Sydney Metro City & Southwest Chatswood to Sydenham section State Significant Infrastructure Application SSI 15_7400

Sydney Metro City & Southwest - Chatswood to Sydenham

SSI 15_7400

CKB Consult Pty Ltd

Figure 7-8 Chatswood dive site (northern) indicative layout

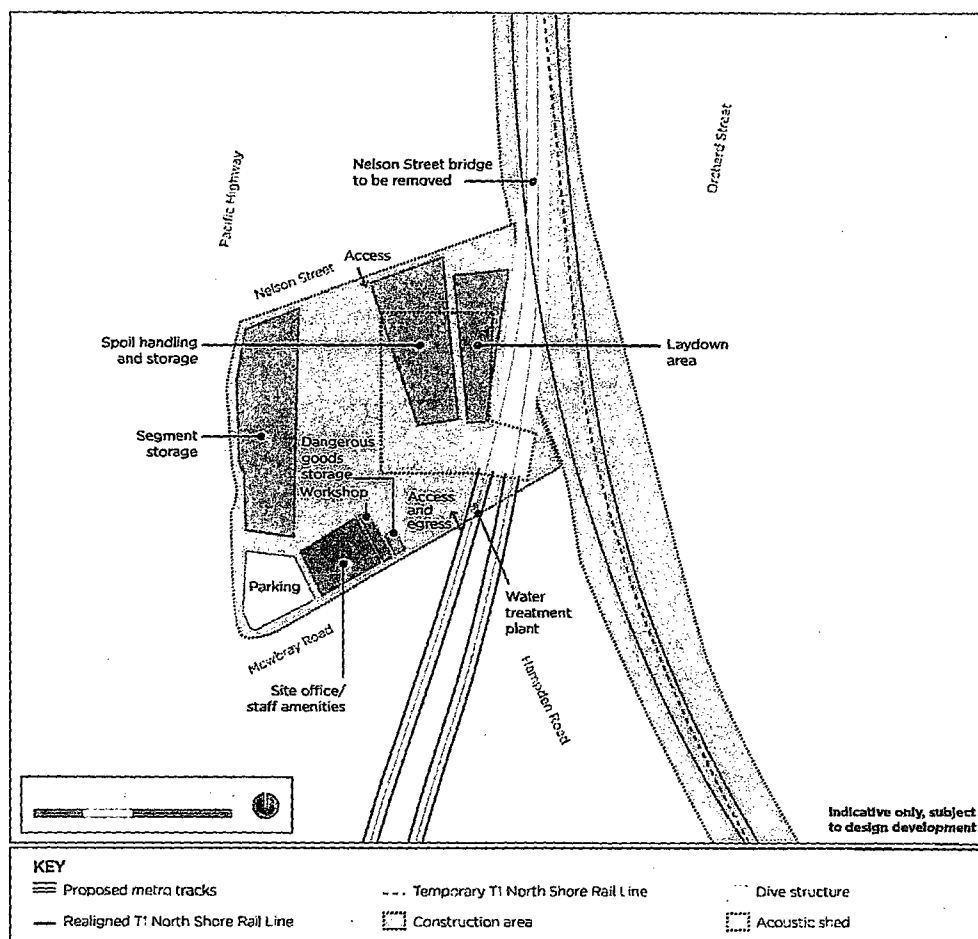
The extensive and heavy construction the works associated with the tunnel dive site and existing rail realignment will generate excessive noise, vibration and dust at 1-3 Gordon Avenue that cannot be mitigated adequately because the rail line is too close to the block, and the upper floor units immediately overlook the works and cannot be screened visually or acoustically;

3. The construction of the bridge to accommodate the new T1 northbound track over the new dive structure requires major rock excavation and piling works immediately adjacent to 1-3 Gordon Avenue, with probable excessive noise and even structural damage.

4. Construction vehicles and material will continuously be moving in the track area adjacent to the 1-3 Gordon Avenue unit block. This construction traffic will occur when preparing the site for the new dive structure, bridge and track foundations for the new t1 northbound location.

5. There is the potential for noise and vibration from existing rail traffic to increase due to the temporary nature of the relocated main northern line.
6. While a noise barrier is planned for the Nelson St construction site, no such noise barrier is proposed between the Gordon Avenue unit block and the excavation area during the excavation work required for the T1 northbound bridge, dive structure and tunnel. This noise barrier is required during the construction of the bridge over the dive structure for T1 northbound. In addition, a noise barrier is required during the building of new Metro tracks.
7. Potential 24x7 work during the construction phase of this project will severely adversely impact residence during and after work hours. There are significant after hours large earth works, demolition, piling and track work proposed in the proximity of 1-3 Gordon Avenue unit block.

Figure 7-7 Northern surface track works

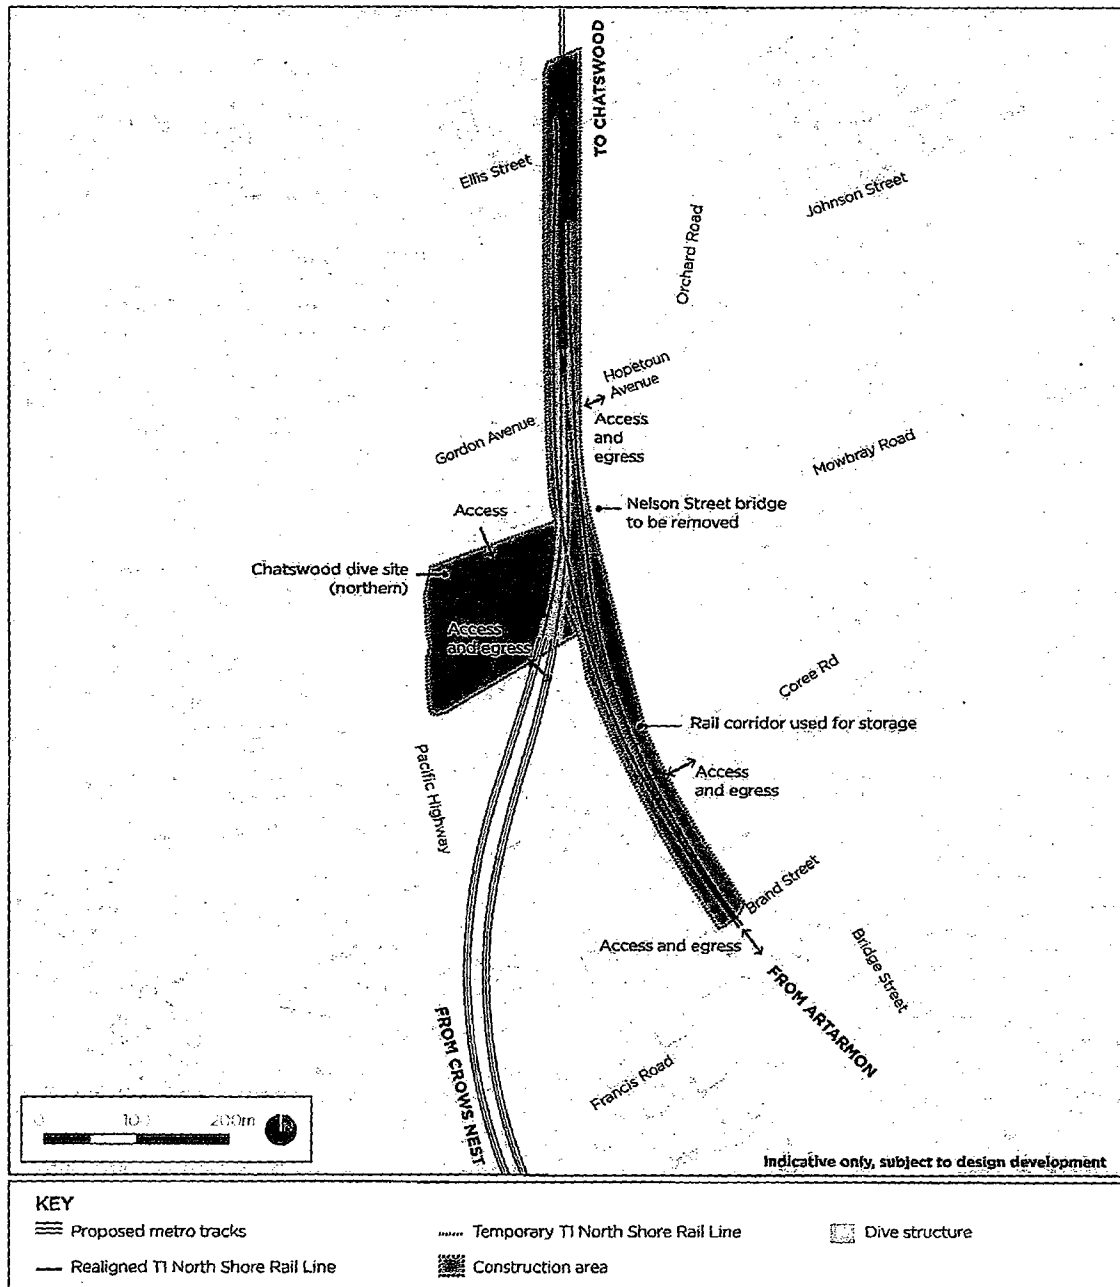
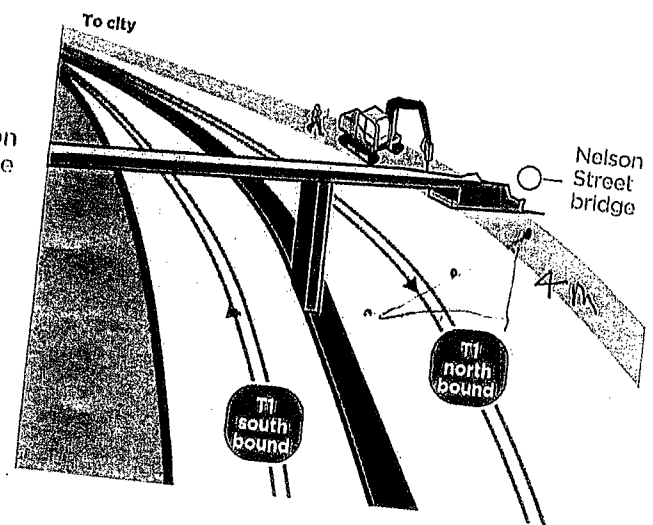
It is proposed to move the northbound heavy rail line closer to 1-3 Gordon Avenue by another three meters, and elevate it by 2m on a bridge structure which will make the noise at our units much worse. This is on top of the existing 3m closer relocation carried out under the Chatswood to Epping project in 2006.

5. The T1 northbound track is raised in height due to being routed over the dive structure. However, in addition to this the dive structure itself finishes at Nelson Street which requires the T1 northbound track to be supported by a concrete bridge structure. This structure will generate significantly more noise than a closed structure and will also allow rail noise from the Metro tracks to pass through to the Gordon Avenue unit block.

2. The realignment of the existing T1 northbound rail line to the temporary route requires heavy machinery and excavation work after hours with multiple rail corridor closure events that will cause severe disruption and noise fatigue effect to the life of all residents.
